Ribble Valley Borough Council
By email

Your ref: 3/2022/1039
Our ref: DC/22/3994 v3
Date: 21-MAR-23

Location: Land adjacent to 115 Kemple View Clitheroe BB7 2QJ

Proposal: Proposed construction of two new detached dwellings with associated access and garden areas

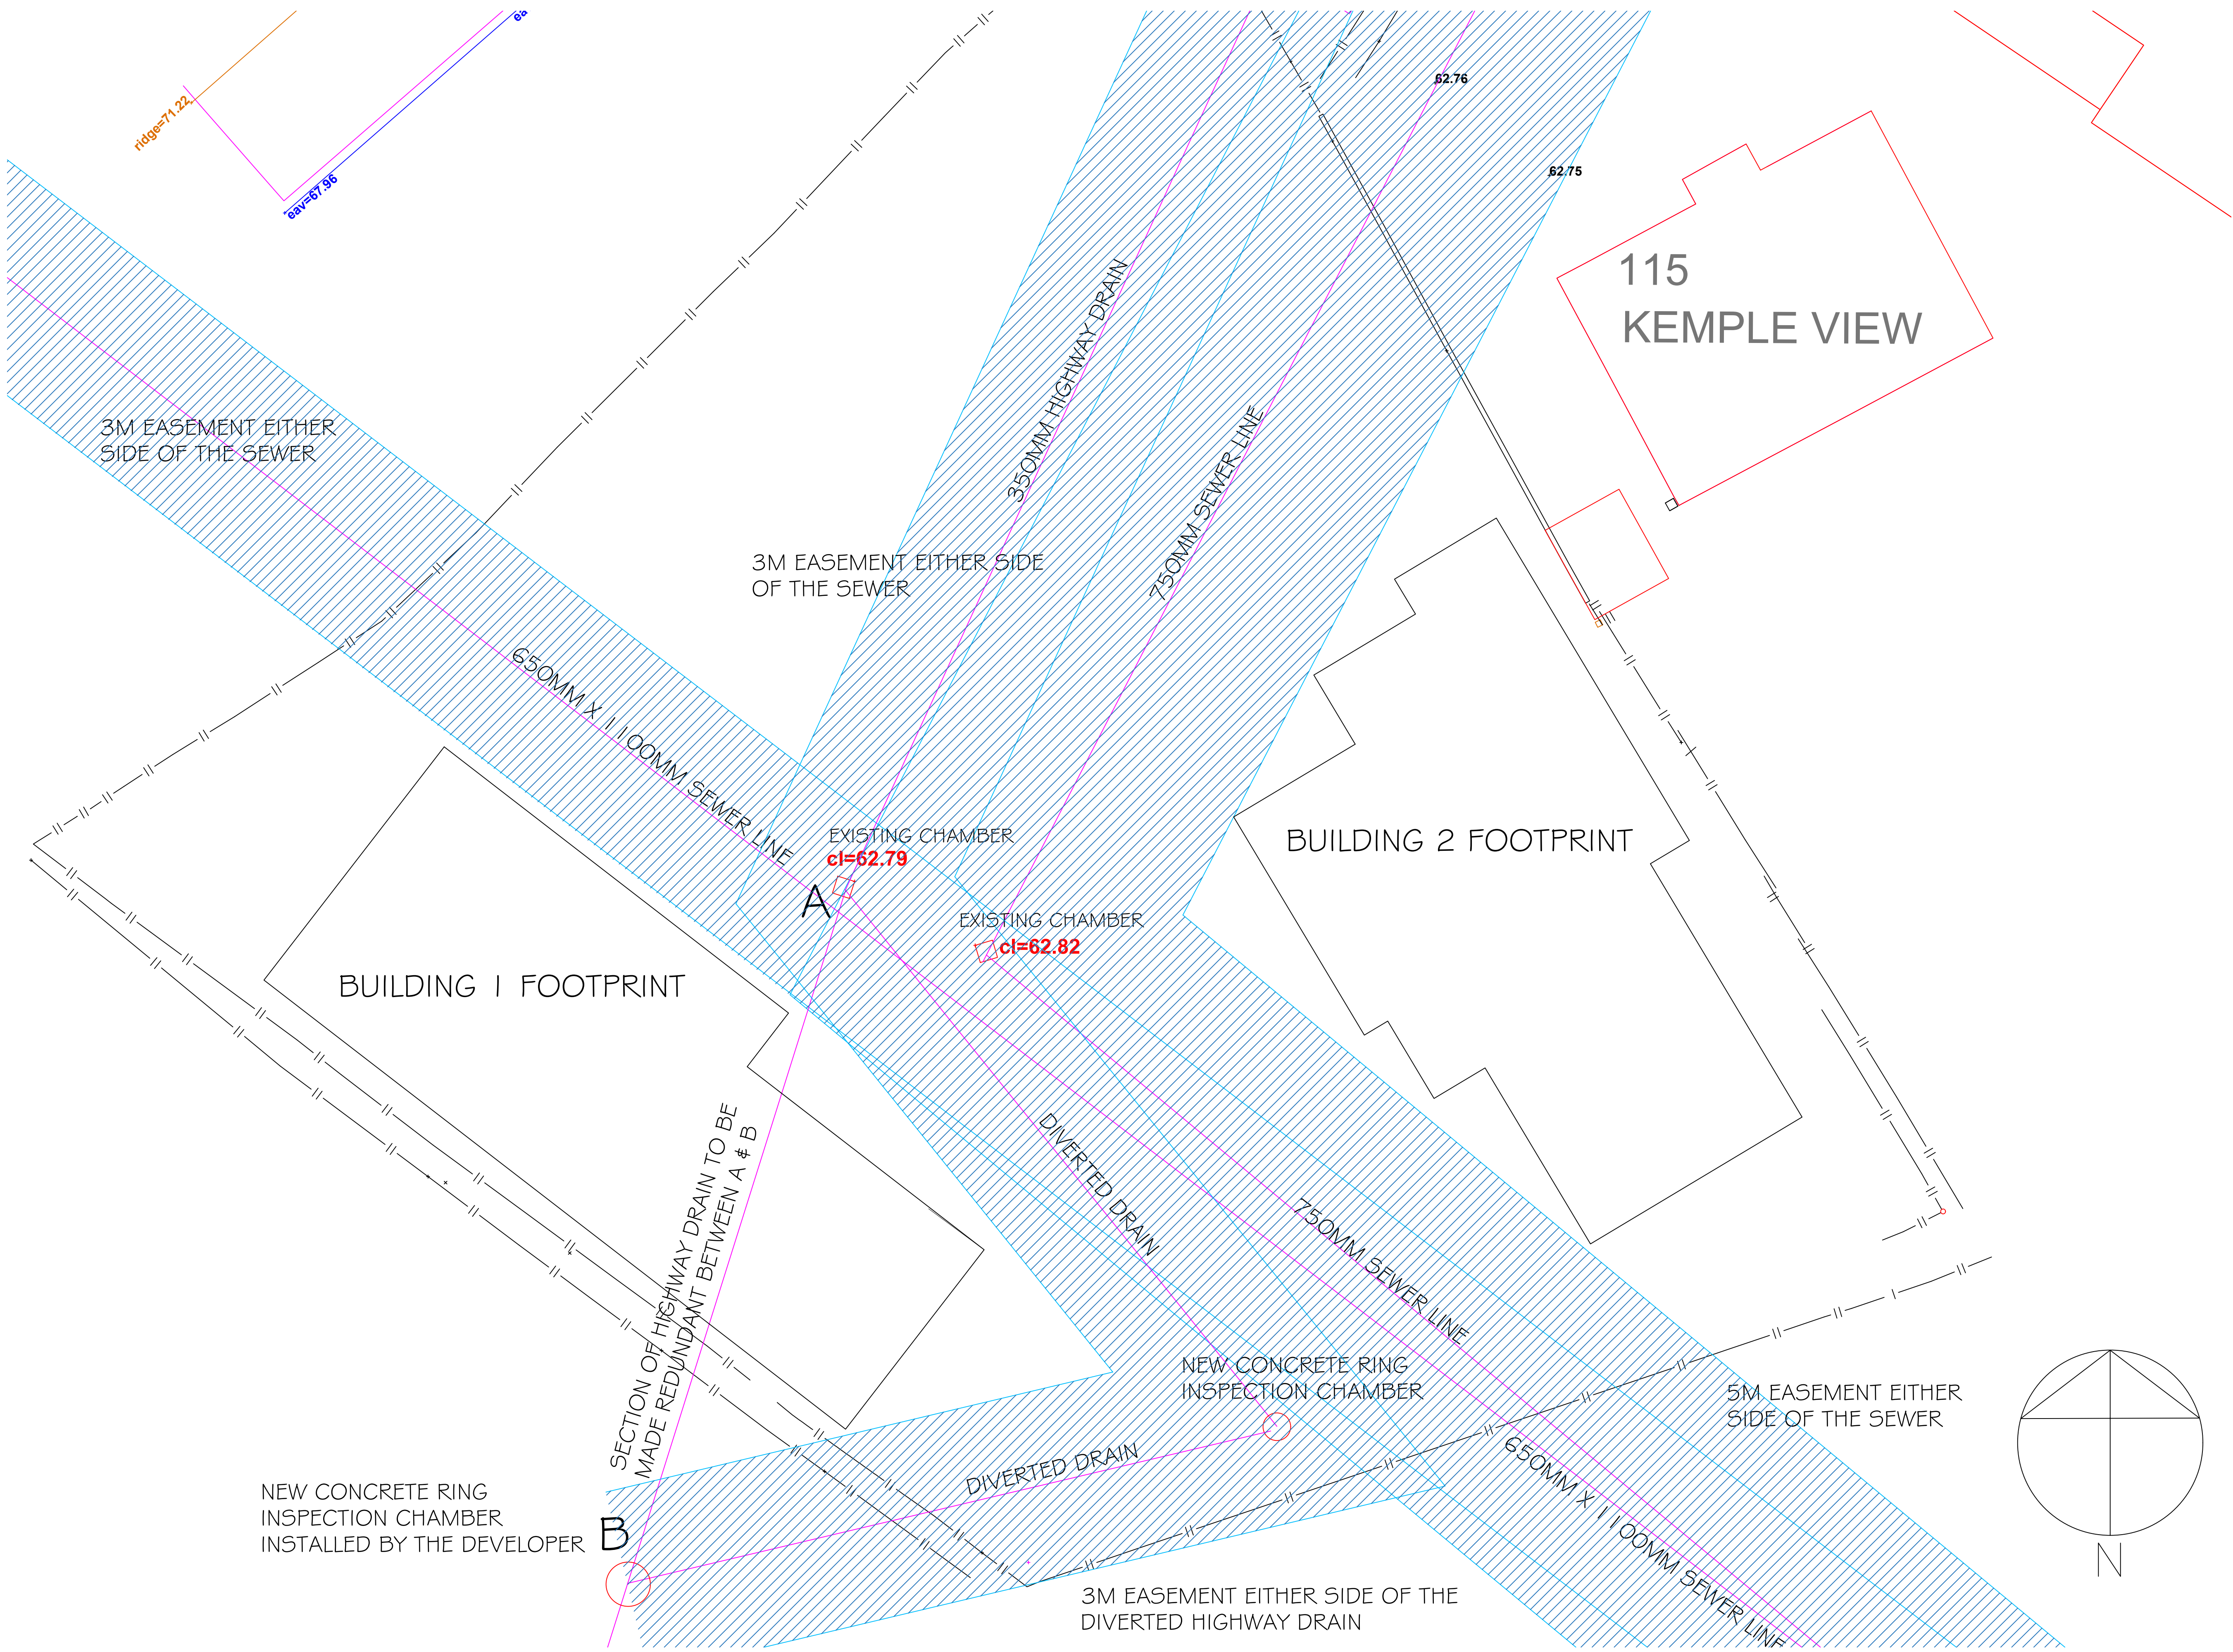
Following our review of the proposed site layout, along with the CCTV investigations of the sewer and the topographical survey it appears that our required access to the public sewers are provided based on the information contained within the Drainage Easements Plan Drawing reference: TRI-1171-02 and the Site Drainage Diversion and Proposed Building Outline plan drawing reference: PHA/366 100. We request that these plans are listed as approved documents on any subsequent Decision Notice.

Following our review of the submitted drainage documents; Drainage Strategy Ref: PHA/366 100, Dated 12.10.2022, the plans are not acceptable to United Utilities. This is because there is insufficient information on the detail of the drainage design and we have not seen robust evidence that the drainage hierarchy has been thoroughly investigated and the proposals are not in line with the Non-Statutory Technical Standards for Sustainable Drainage Systems

Prior to the commencement of development, details of a sustainable surface water drainage scheme and a foul water drainage scheme shall be submitted to and approved in writing by the Local Planning Authority. The drainage schemes must include:

- (i) An investigation of the hierarchy of drainage options in the National Planning Practice Guidance (or any subsequent amendment thereof). This investigation shall include evidence of an assessment of ground conditions and the potential for infiltration of surface water in accordance with BRE365;***
- (ii) A restricted rate of discharge of surface water agreed with the local planning authority (if it is agreed that infiltration is discounted by the investigations);***
- (iii) Levels of the proposed drainage systems including proposed ground and finished floor levels in AOD;***
- (iv) Incorporate mitigation measures to manage the risk of sewer surcharge where applicable; and***
- (v) Foul and surface water shall drain on separate systems.***
